WEST SUSSEX COUNTY COUNCIL CONSULTATION

TO:	Arun District Council - FAO: Simon Davis
FROM:	WSCC - Highways Authority
DATE:	29 November 2021
LOCATION:	Sefter Farm Pagham Road Pagham PO21 3PX
SUBJECT:	P/117/21/PL Construction of a new packhouse including relocation of parking area and landscaping. This site may affect the setting of a listed building and is in CIL Zone 5 (Zero Rated) as other development. Supplementary Information re Highways and Parking received.
RECOMMENDATION:	More Information

HGV Routes Through the Proposed Site

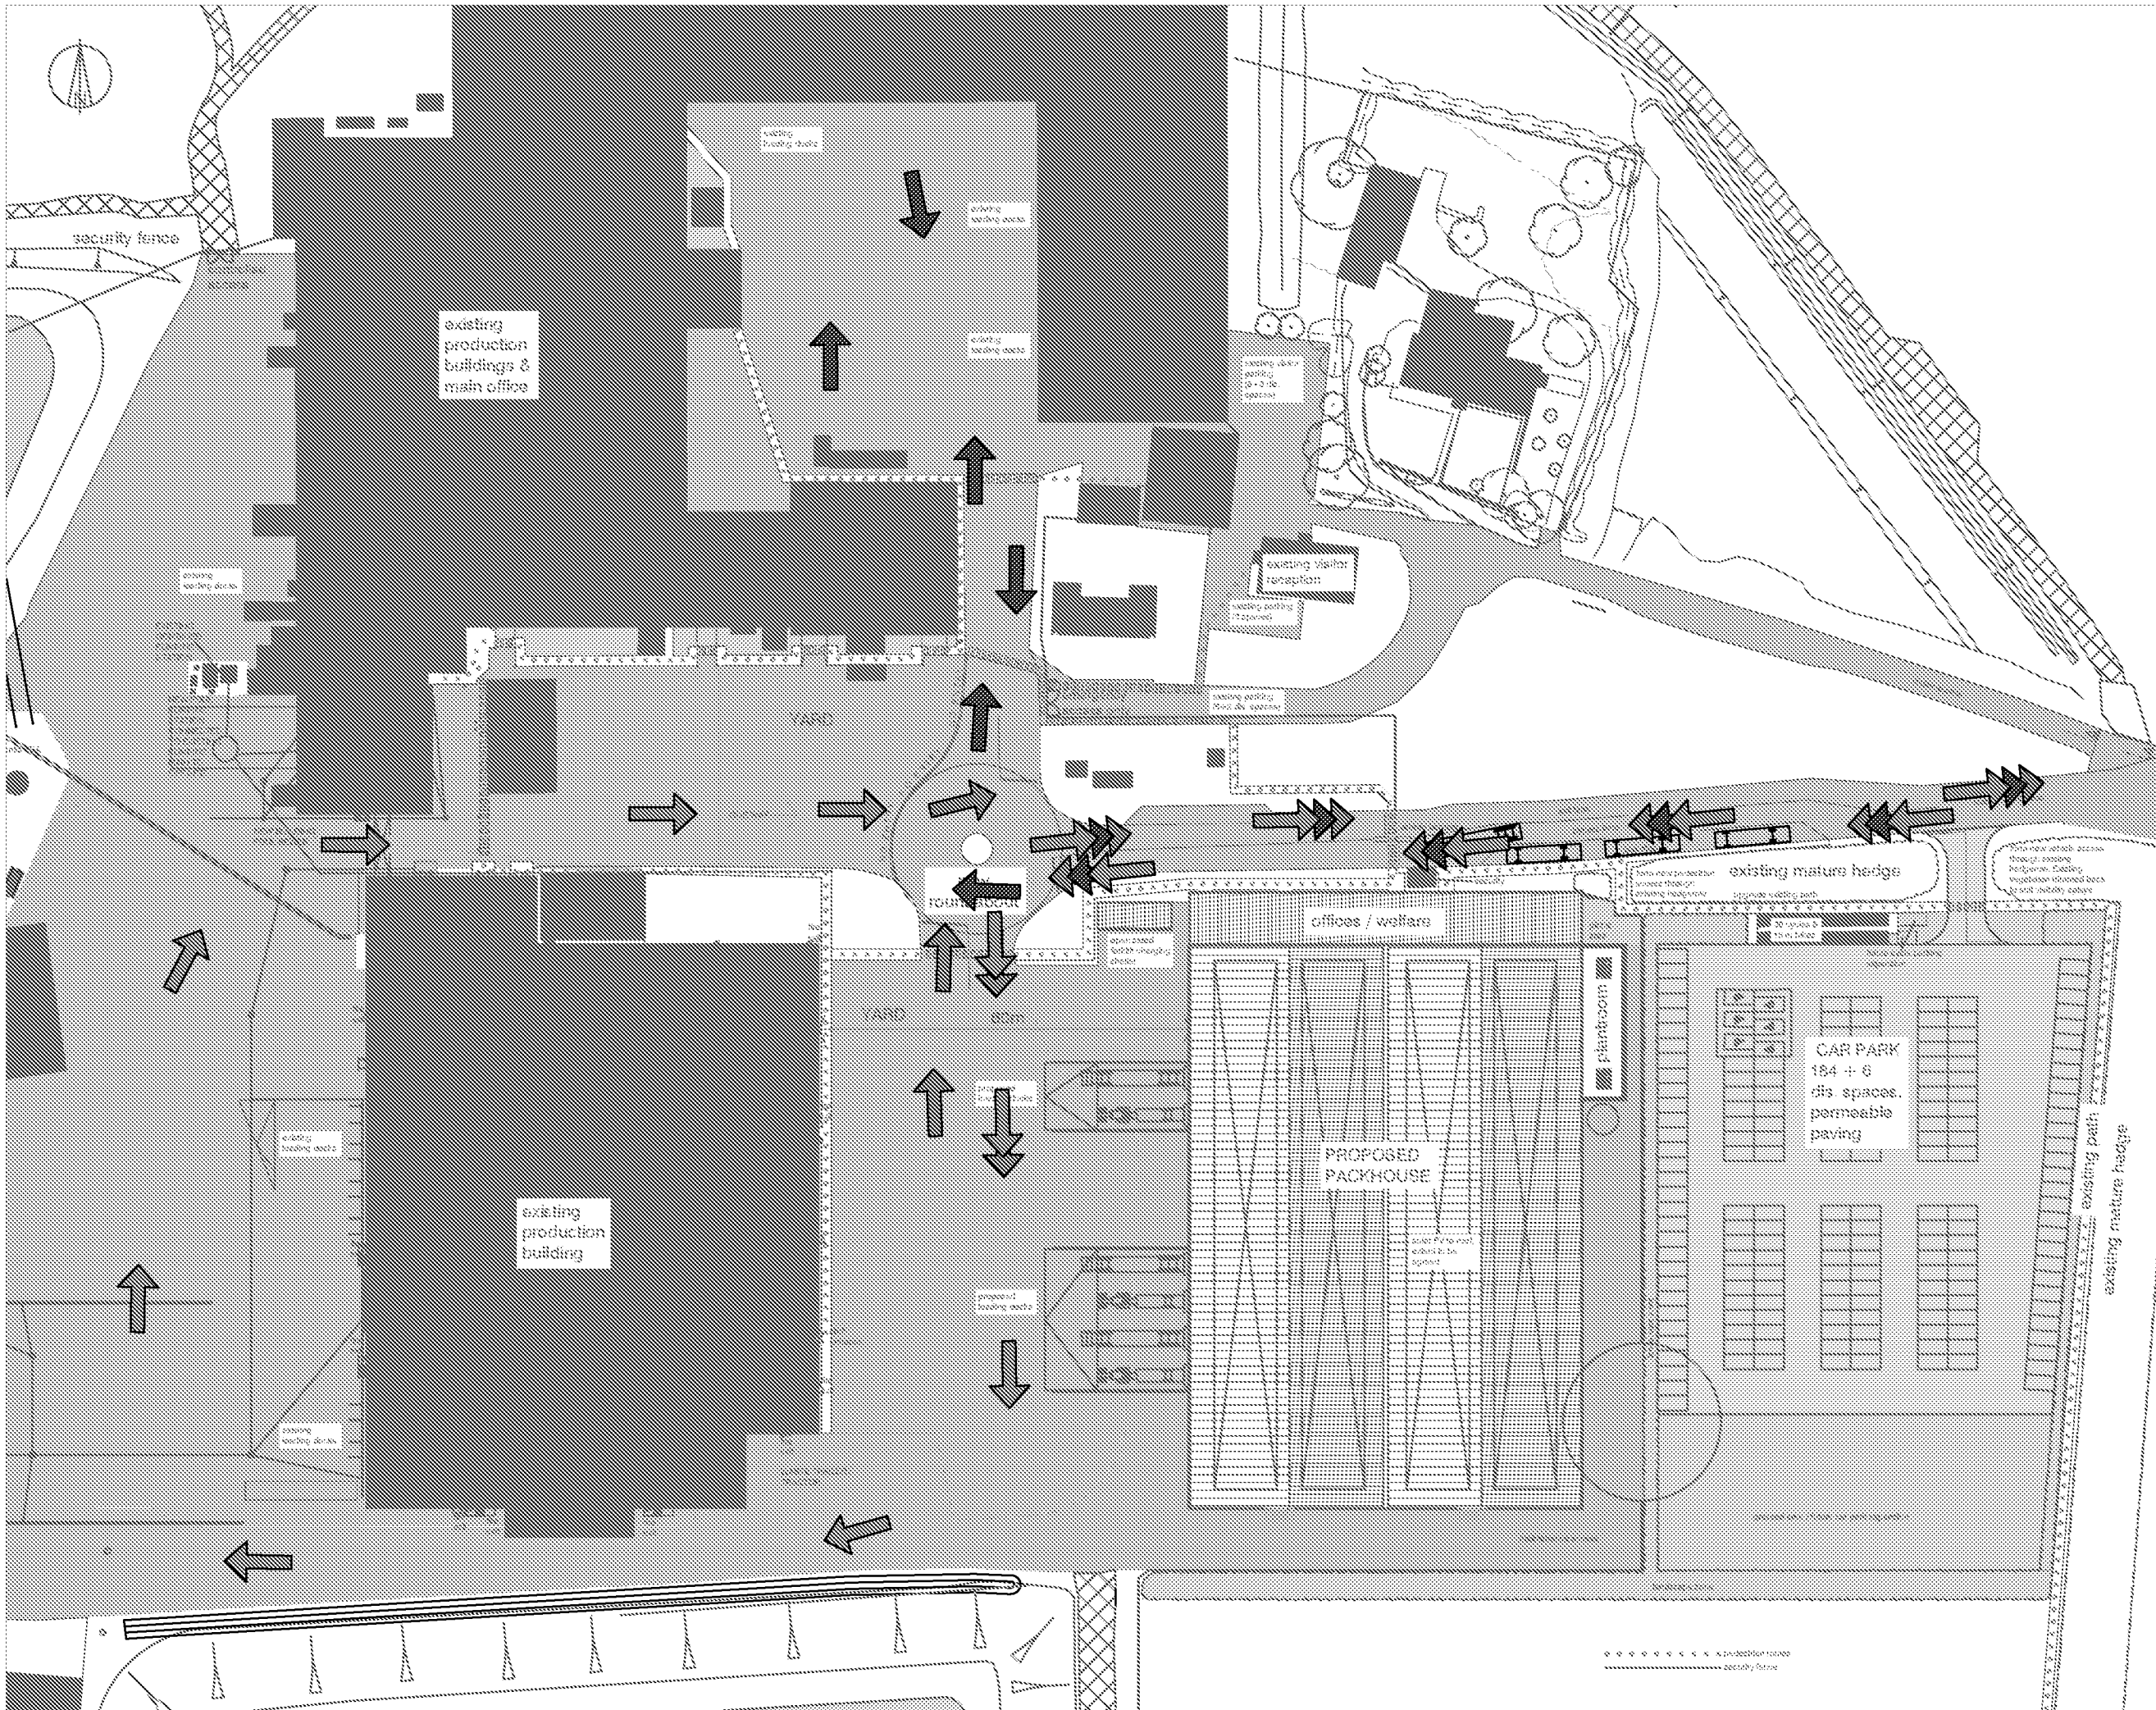
HGV routes throughout the site have been detailed to clearly show the proposed amended layout within the site.

Car Parking Plan

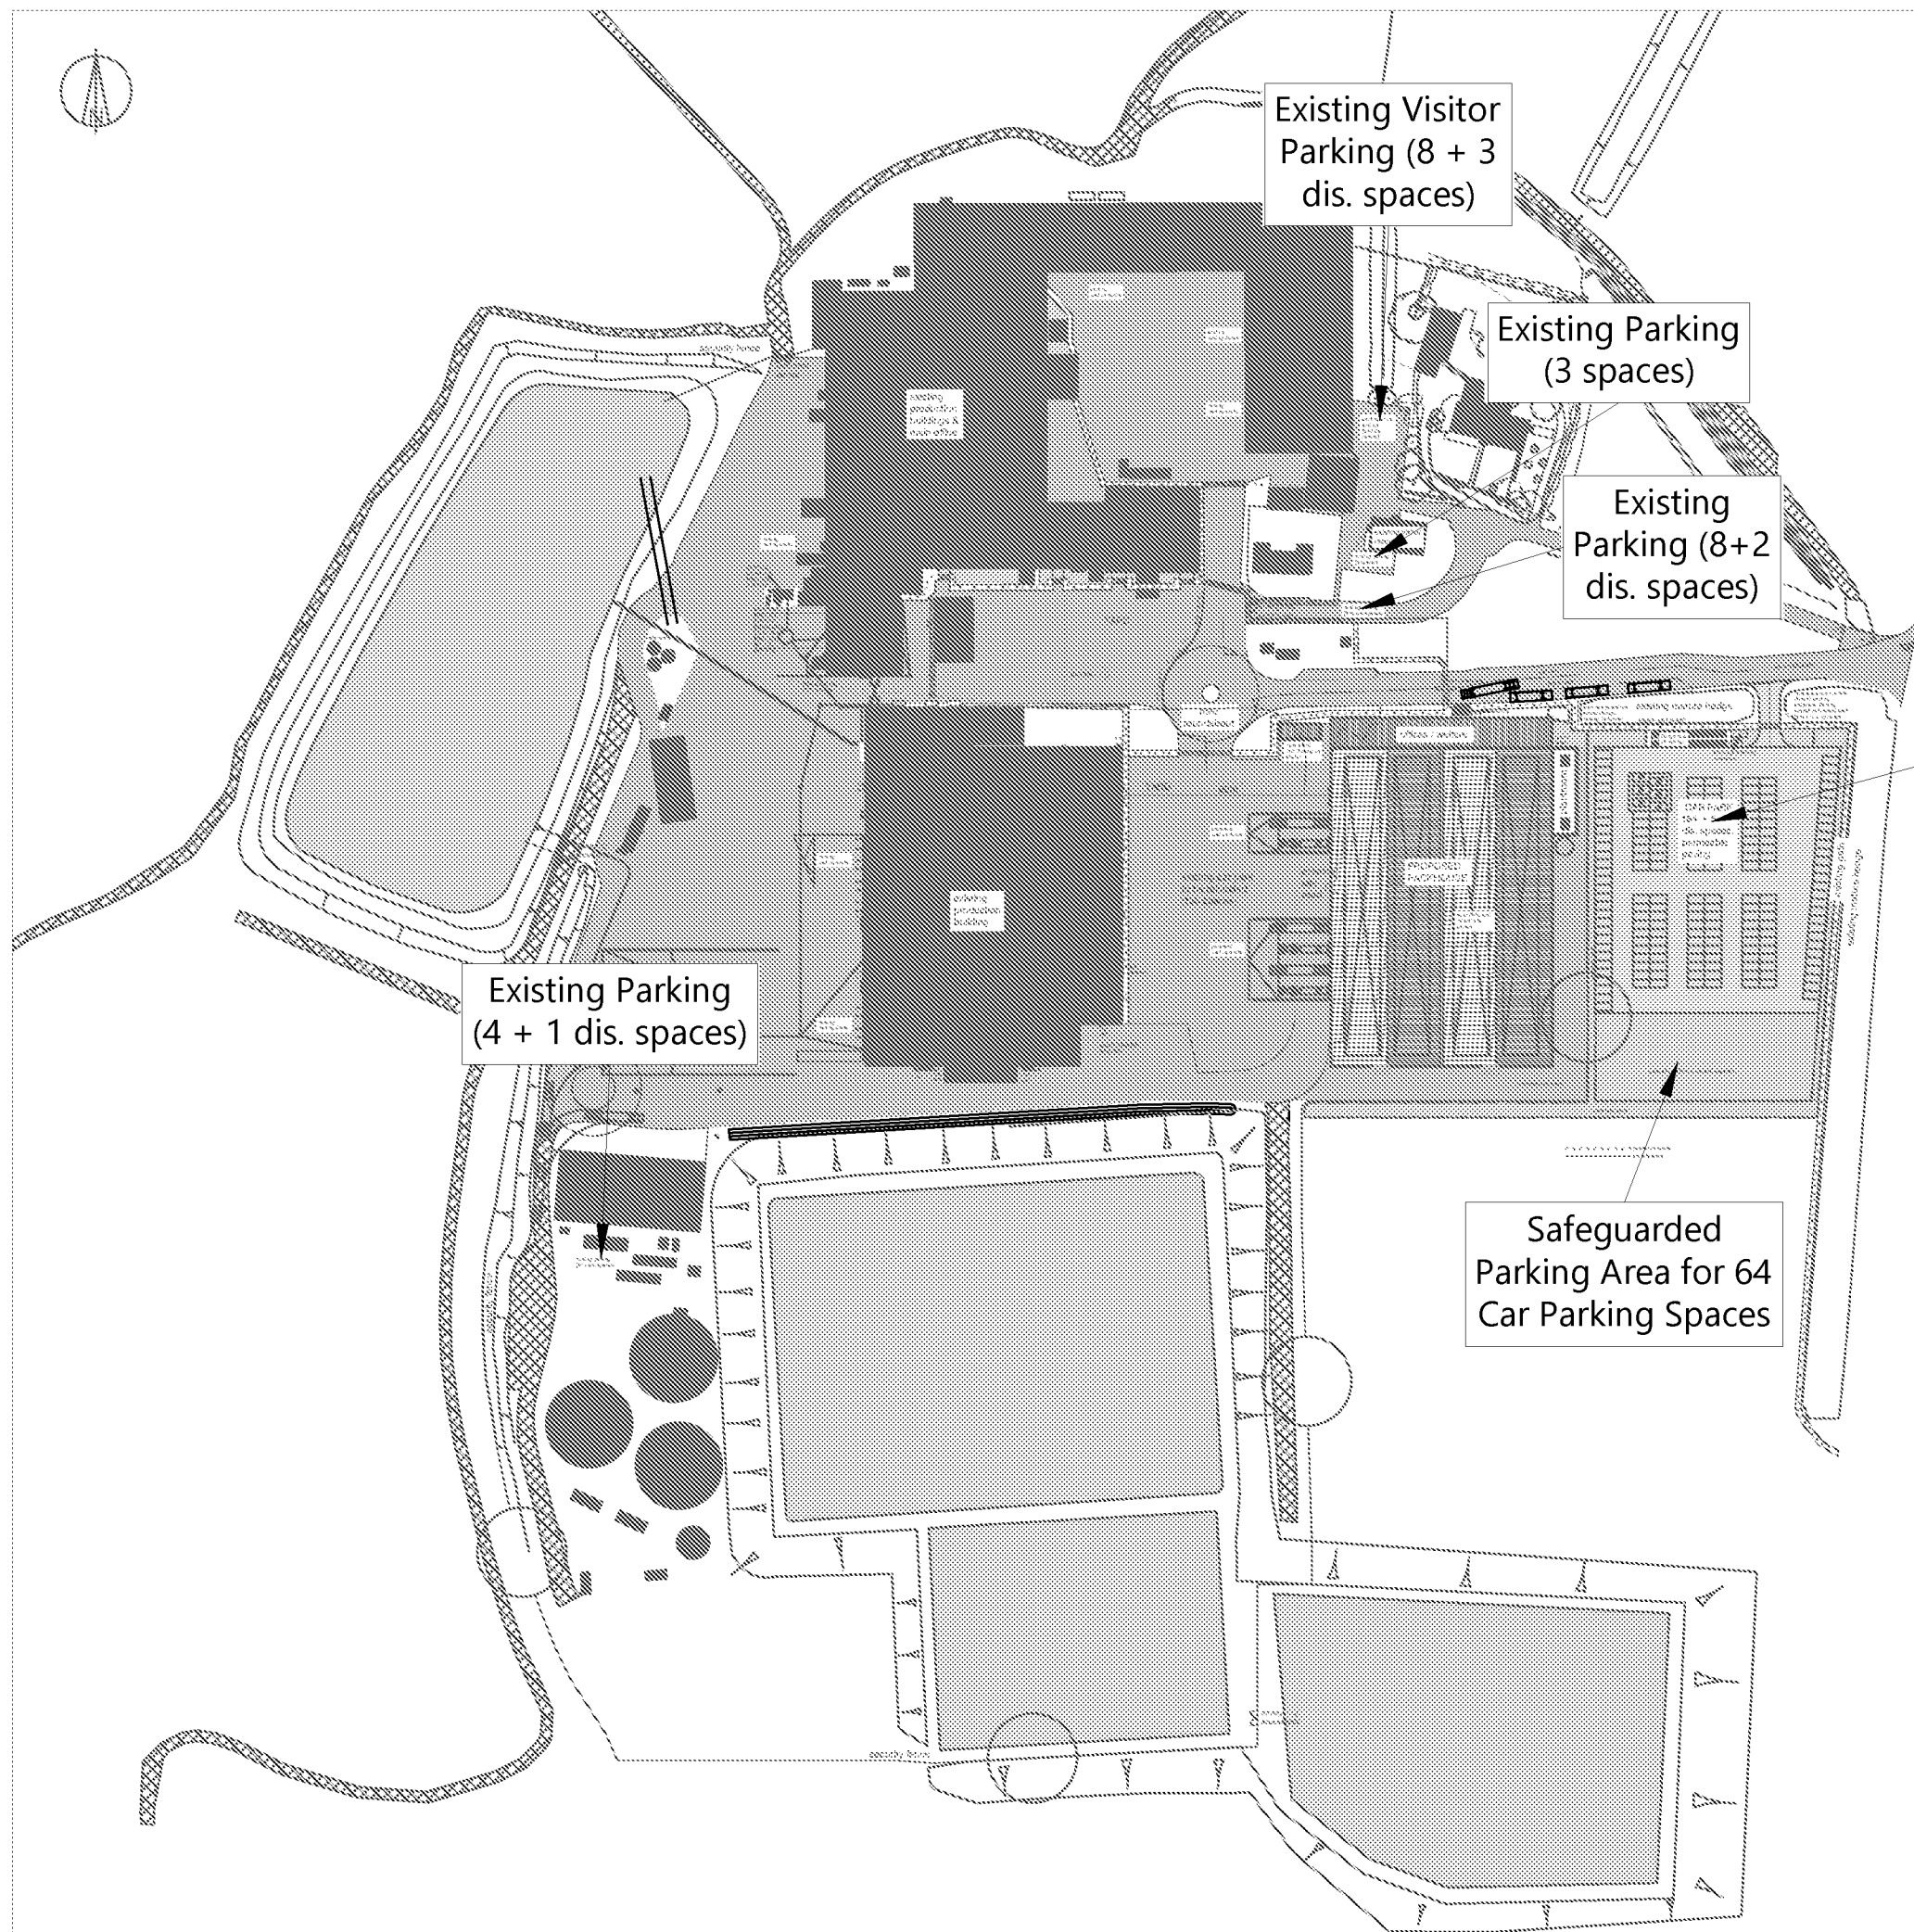
A plan showing the existing 219 x car parking across the site has been provided. A safeguarded area for 64 x additional parking spaces has also been annotated. The 64 x spaces would be provided in line with Arun SPD requirement for 1 space per 100sqm for B8 storage use.

The LHA consider there is sufficient space within the site for car and HGV parking although finer detail (are the 64 x spaces proposed to be built as part of this application?) disabled, bicycle and motorcycle parking and electric vehicle spaces can be secured by condition.
